WEST SUSSEX COUNTY COUNCIL CONSULTATION

TO:	Arun District Council FAO:Raymond Coles
FROM:	WSCC - Highways Authority
DATE:	9 June 2021
LOCATION:	Land north of Hook Lane Pagham
SUBJECT:	P/132/20/RES Approval of reserved matters following P/30/19/OUT for 300 No. new homes, internal roads, footpaths & cycleways, car parking & landscaping. This application affects the setting of a listed building & falls within Strategic Site H SP2, CIL Zone 1 (Zero Rated)
DATE OF SITE VISIT:	n/a
RECOMMENDATION:	Advice - Modification
S106 CONTRIBUTION TOTAL:	n/a

For the purpose of this response, the following drawings have been reviewed,

Project **Hook Lane, Pagham**
Drawing **Refuse Strategy Layout**

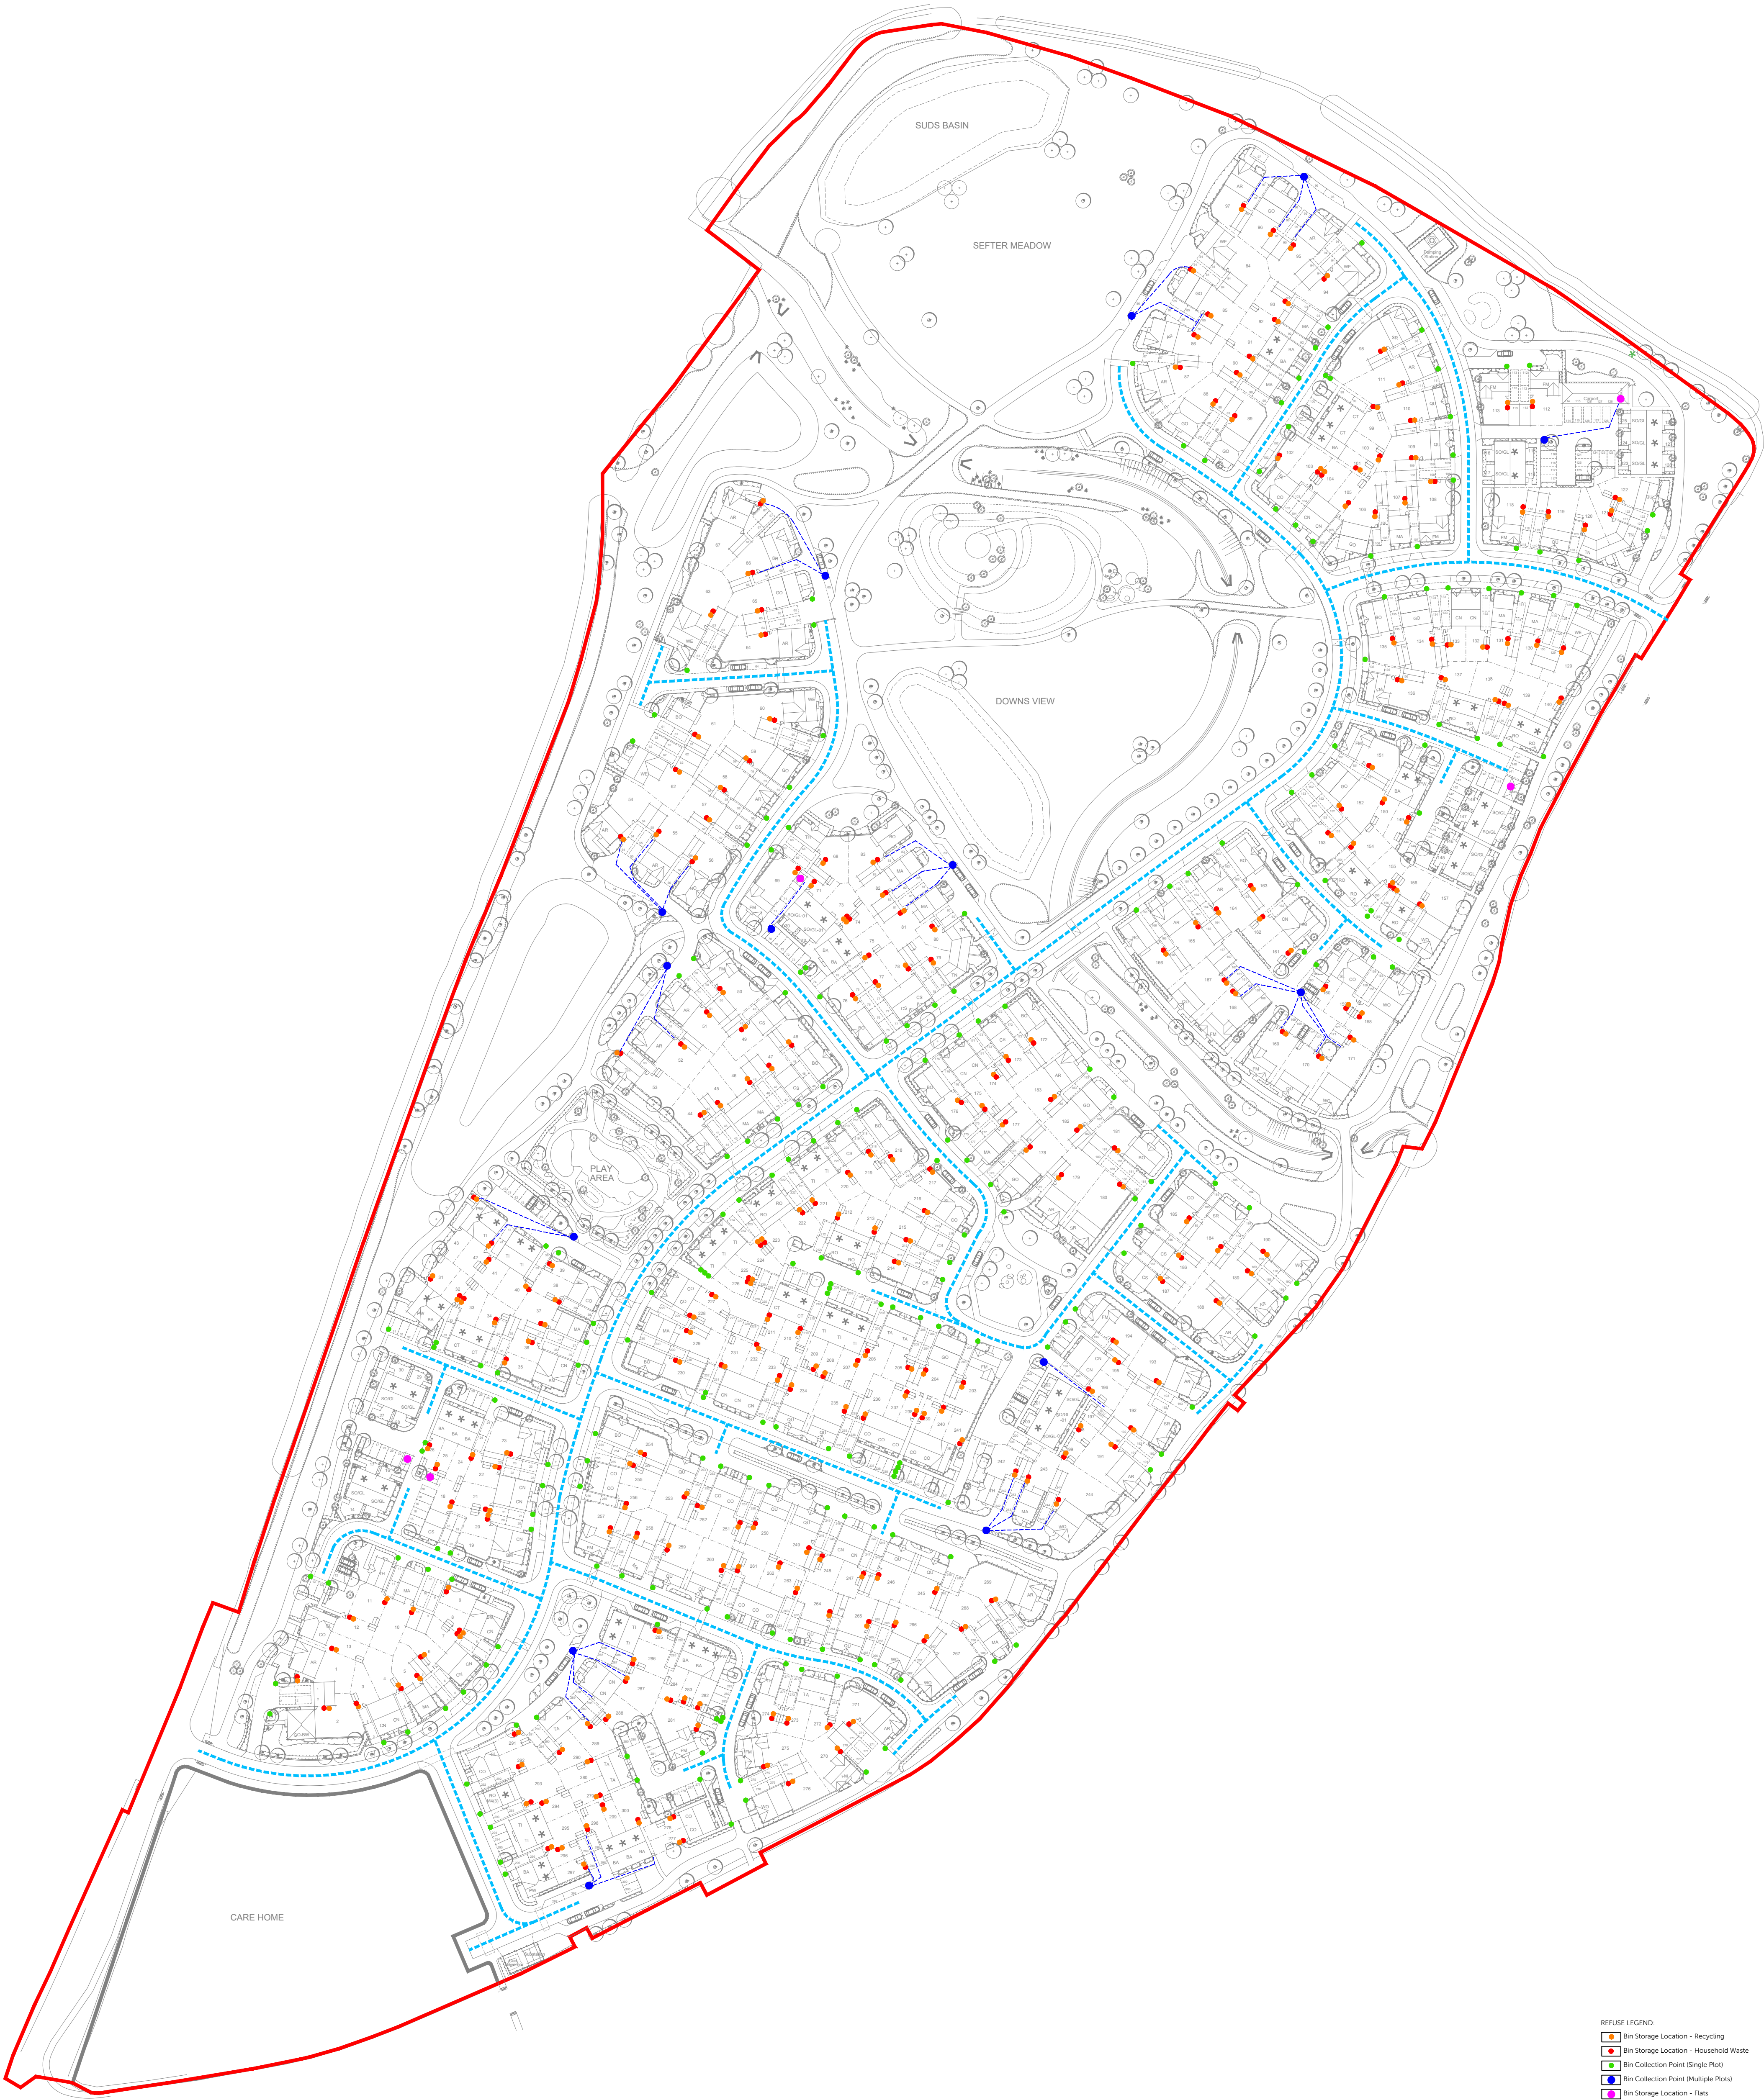
The only additional comment that would be offered at this stage is in respects of the refuse vehicle tracking and the footway requirement on the eastern side of the open space labelled 'Downs View'. With the refuse tracking, the point has already been made by WSCC Highways that the tracking is very tight with there being areas of private curtilage that a refuse vehicle would overhang. However some of the revised tracking particularly on sheet 1 shows the tracking to be incredibly tight to some parking spaces (e.g. spaces close to plots 14, 194, 195, 271, 274 to name just some). The Refuse Collection team at the District Council must be consulted.
